Hi Andy

Further to the City's correspondence regarding the RtS dated 25 March 2021, please find further advice from the City's Public Domain team. I apologise for the delay in providing this information.

Sheet Title
Landscape Masterplan - GFLevel

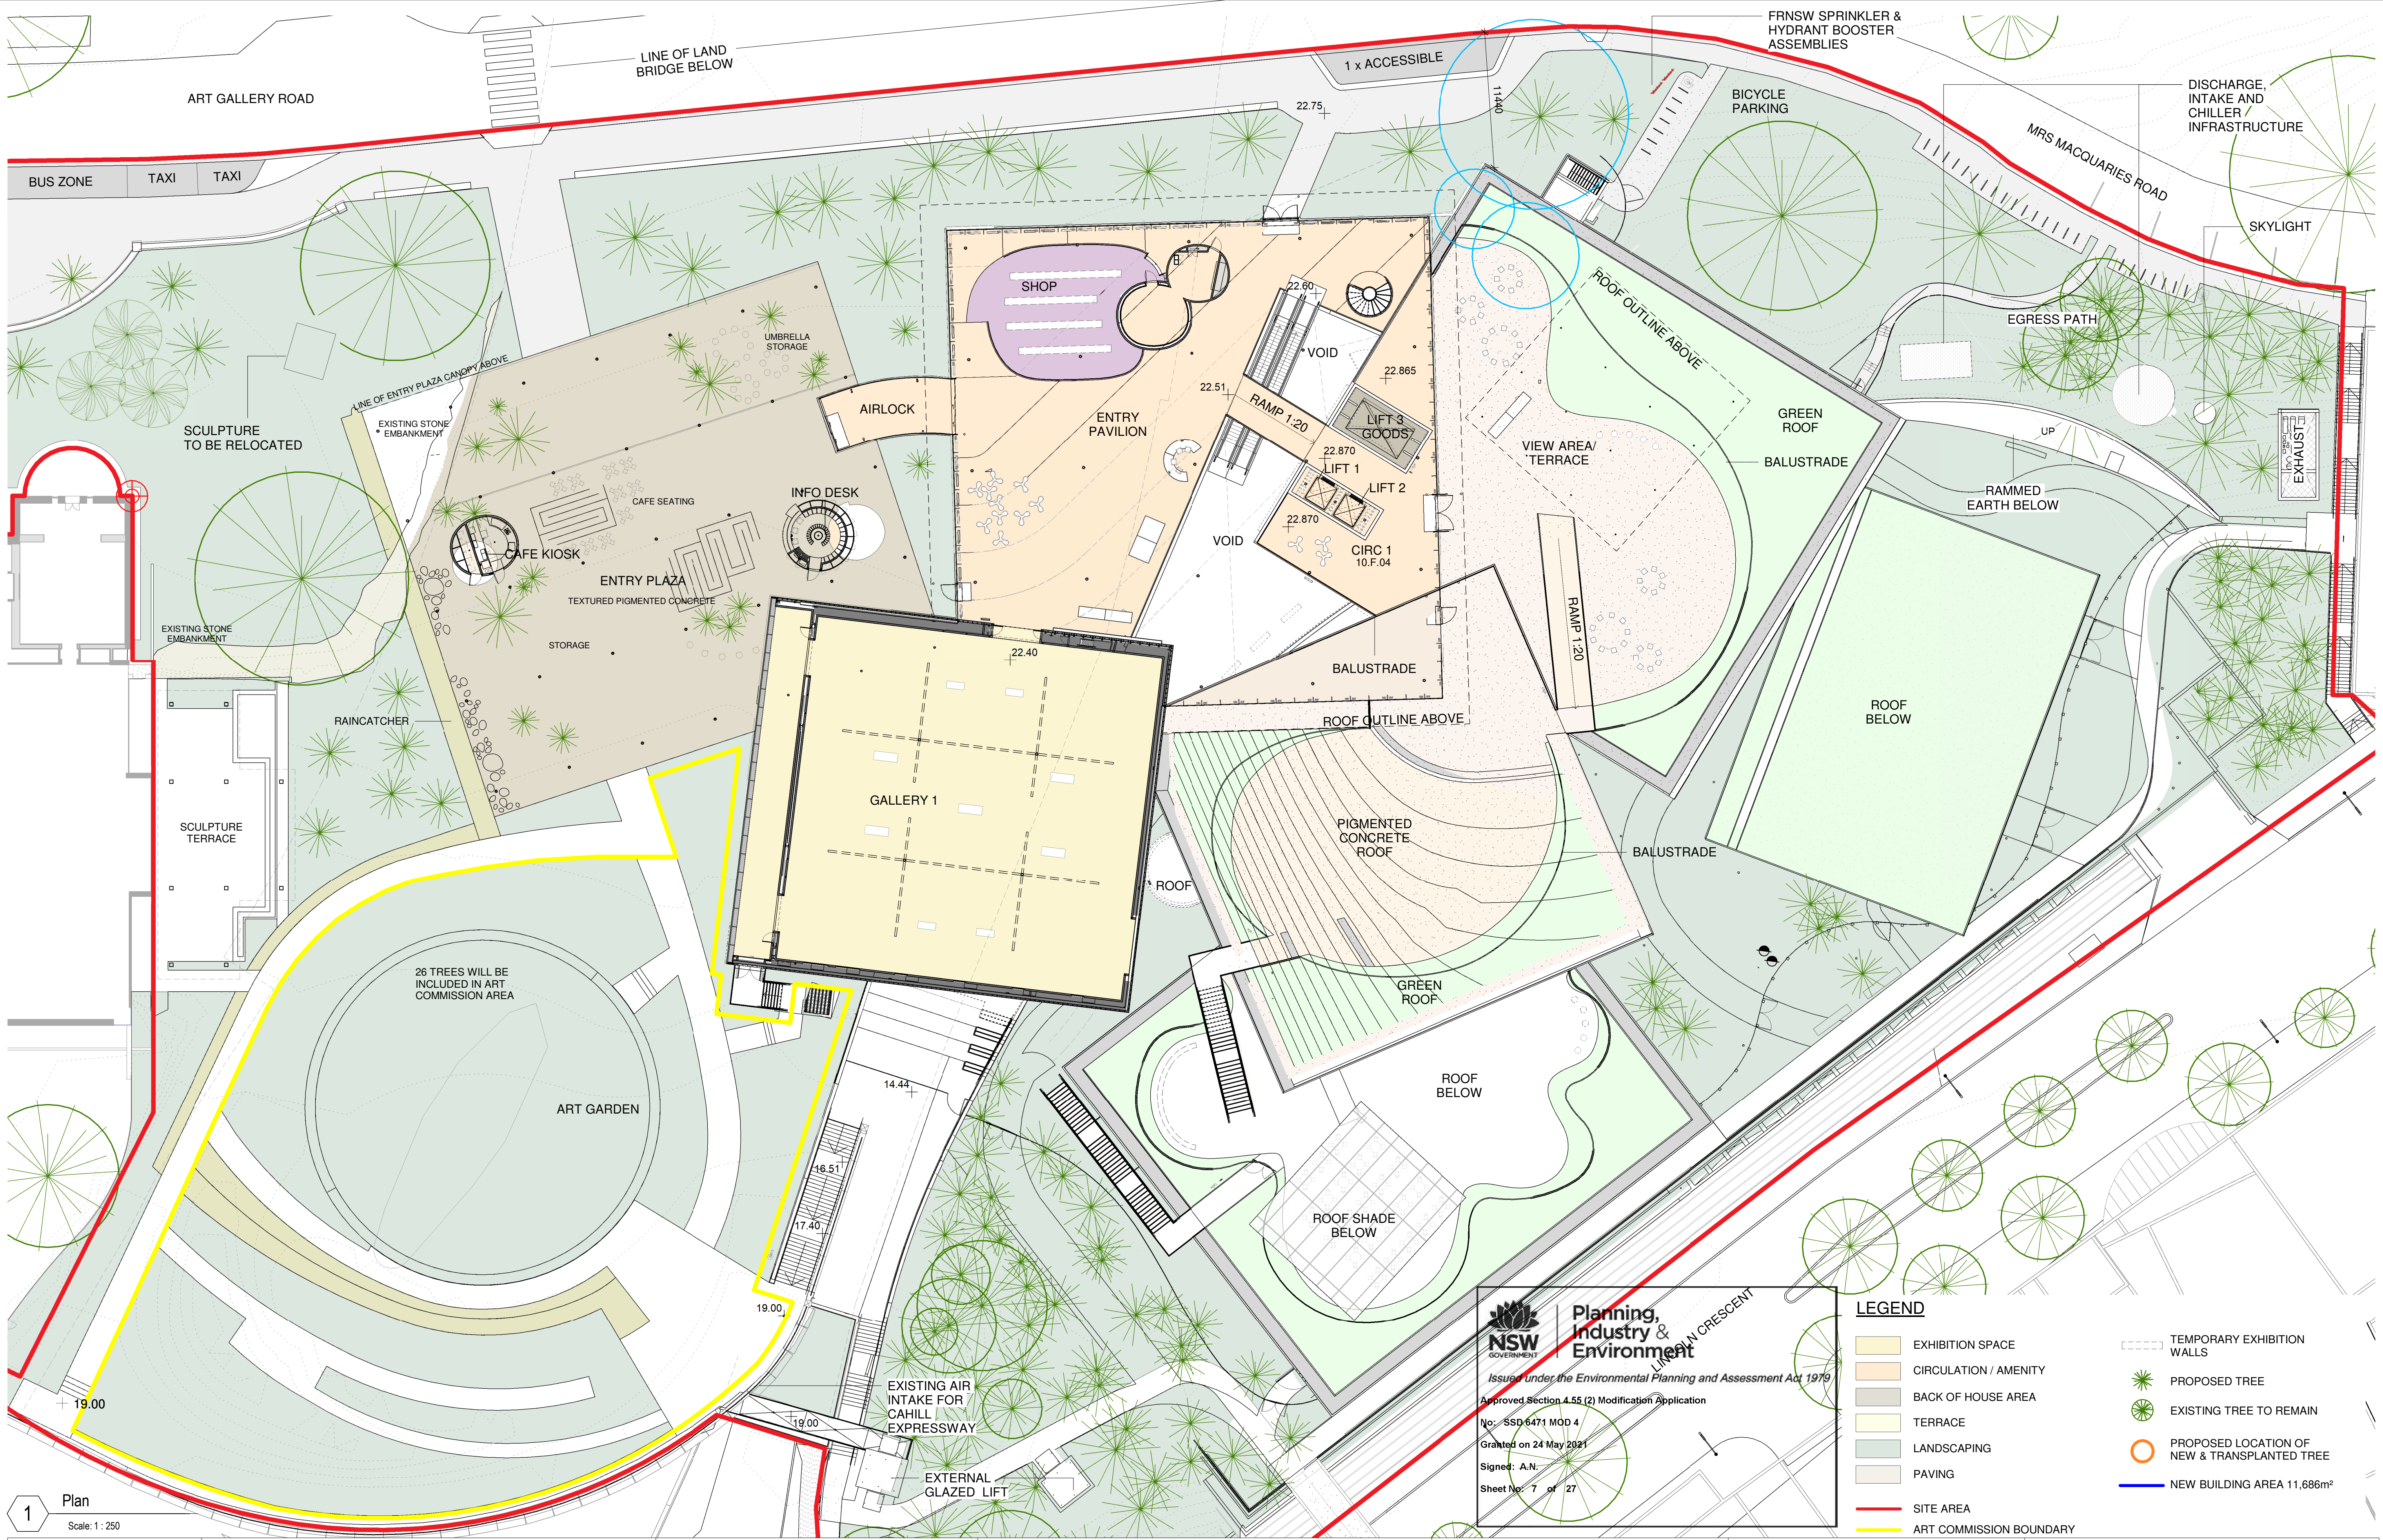
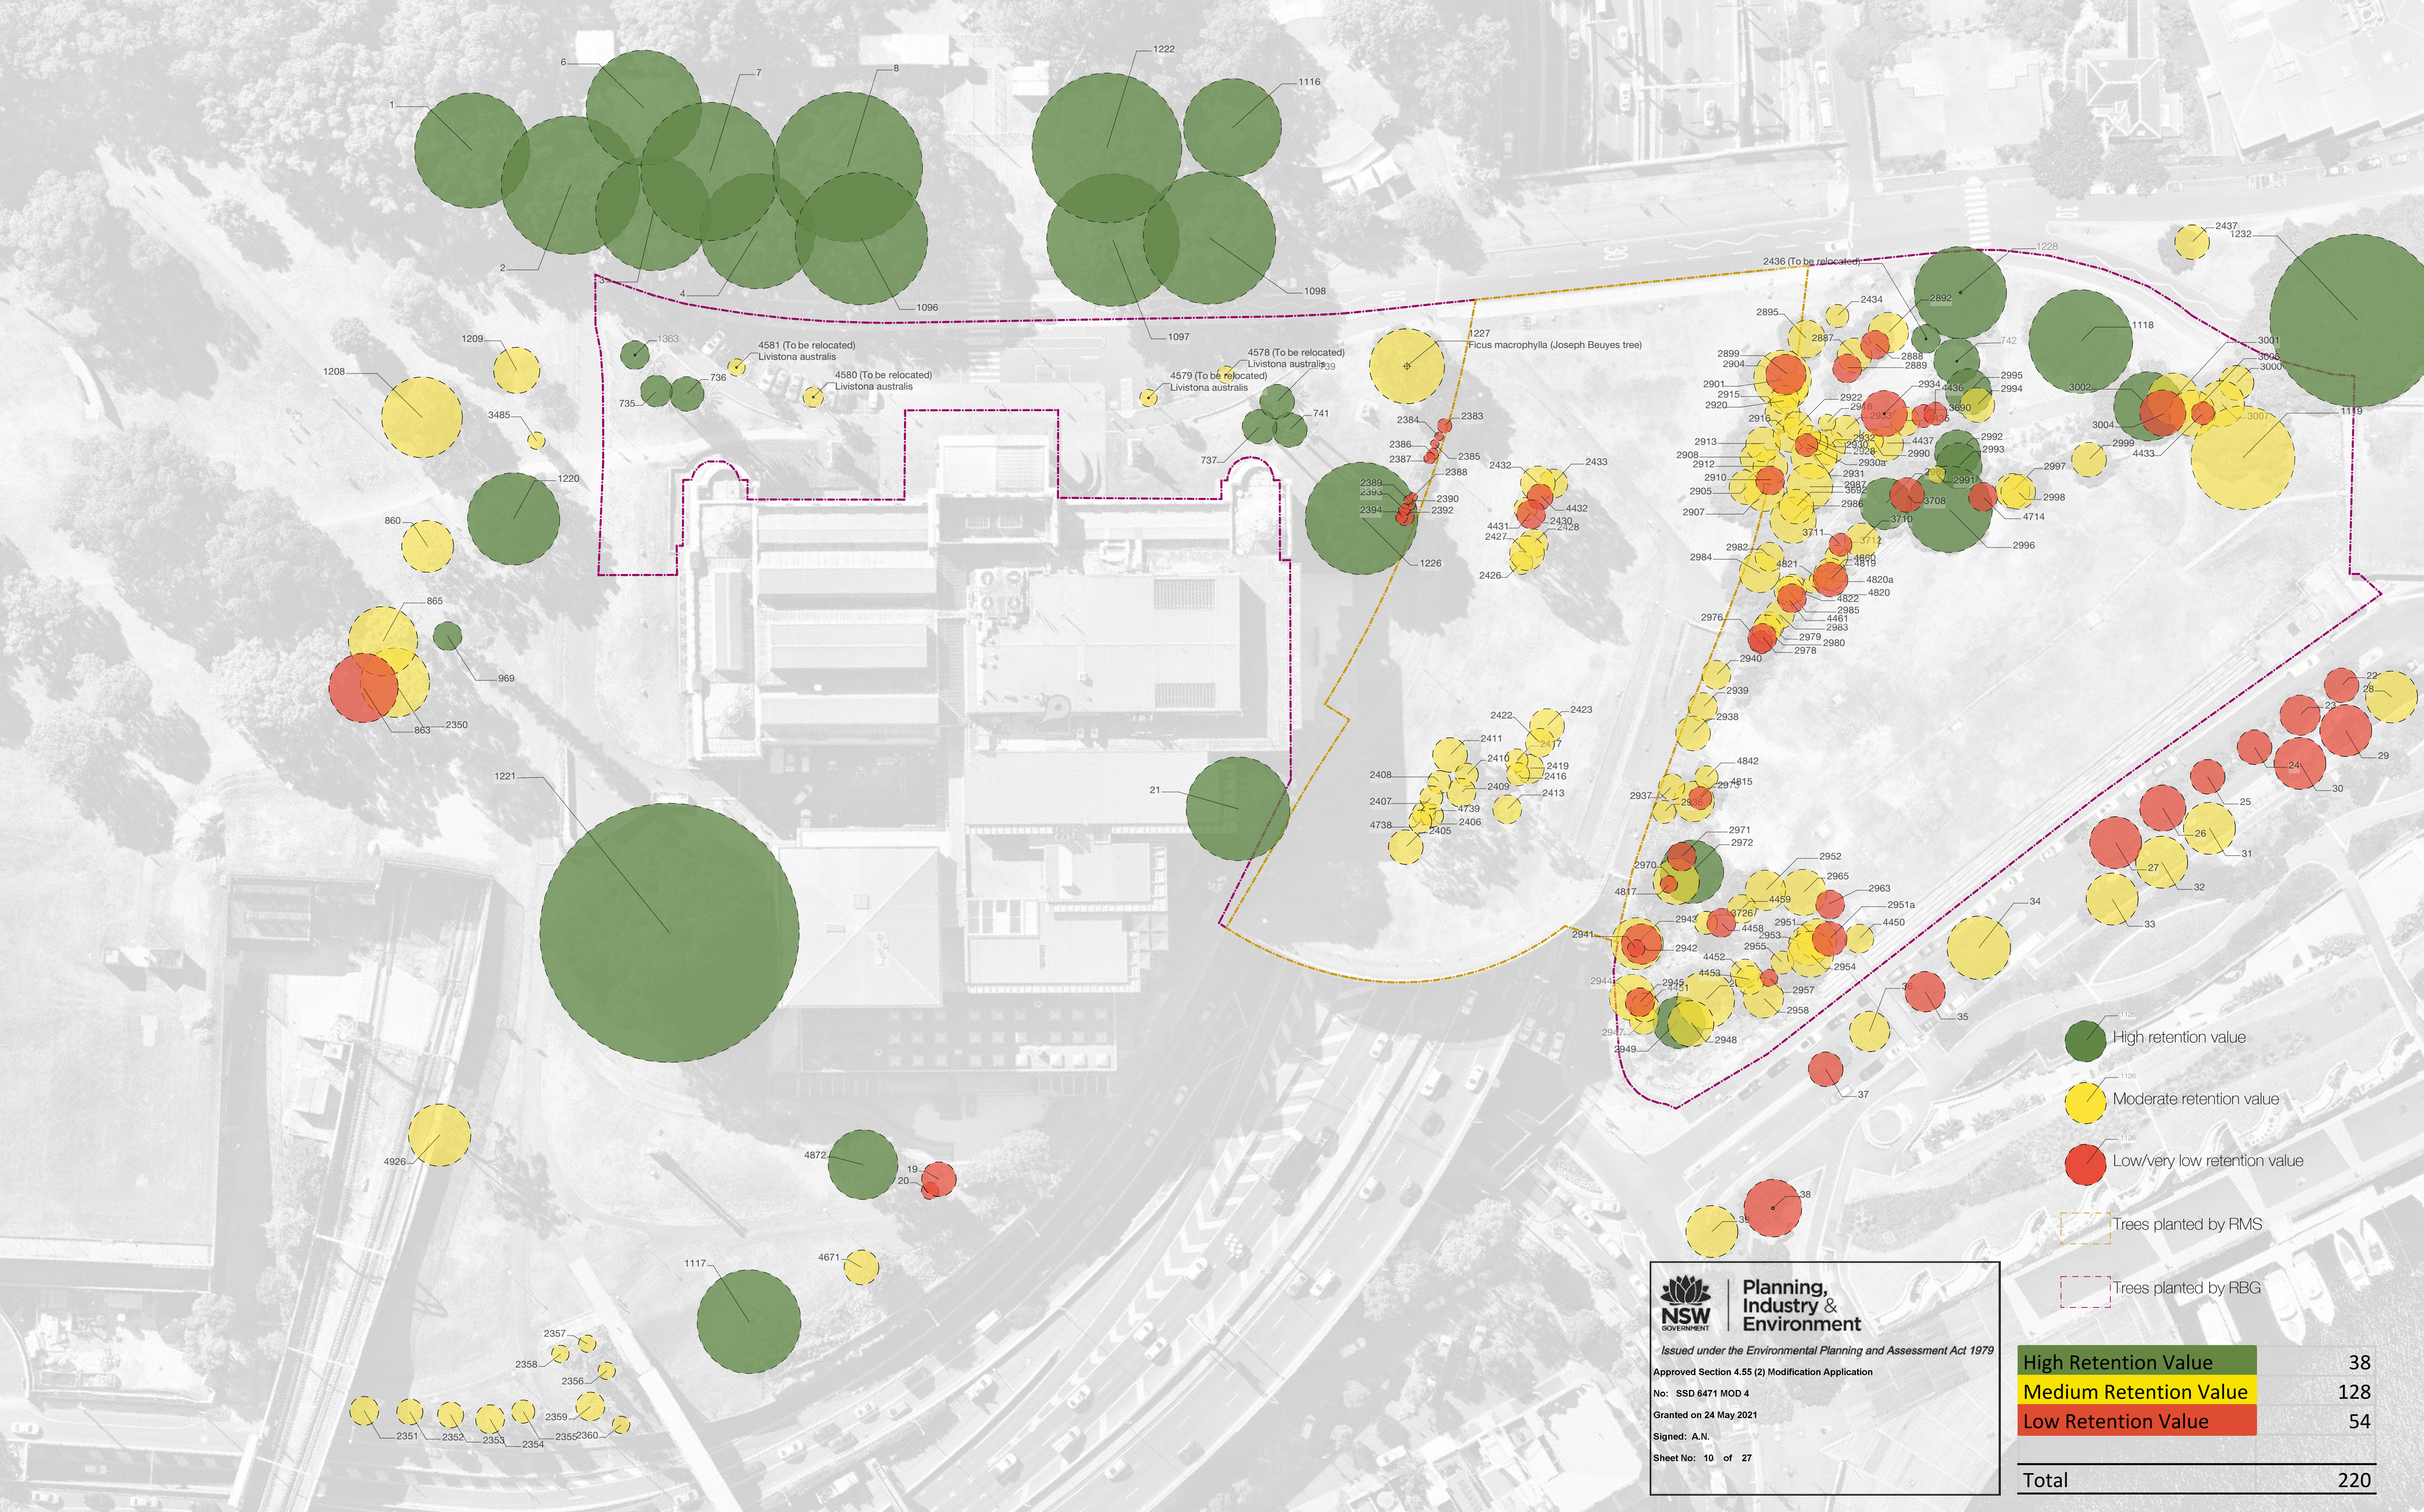
- A mix of paving materials is shown around the asphalt paving to the north – there is granite, then asphalt and then concrete. The previous landscape plans showed granite extending along the Art Gallery Road footpath as well as throughout the area connecting to Sydney Modern. It is understood that the land bridge has a load limit, but that concrete would not have any significant weight difference to asphalt. It is therefore suggested that the asphalt path along Art Gallery Road be finished in concrete to match the paths through to Sydney Modern. This will reduce materials and a patchy appearance, as well as reduce the *heat island* effect of asphalt.

- The circle of lawn to the north of the main entrance should connect through to the quadrangle to Sydney Modern so that the area can function for both venues.
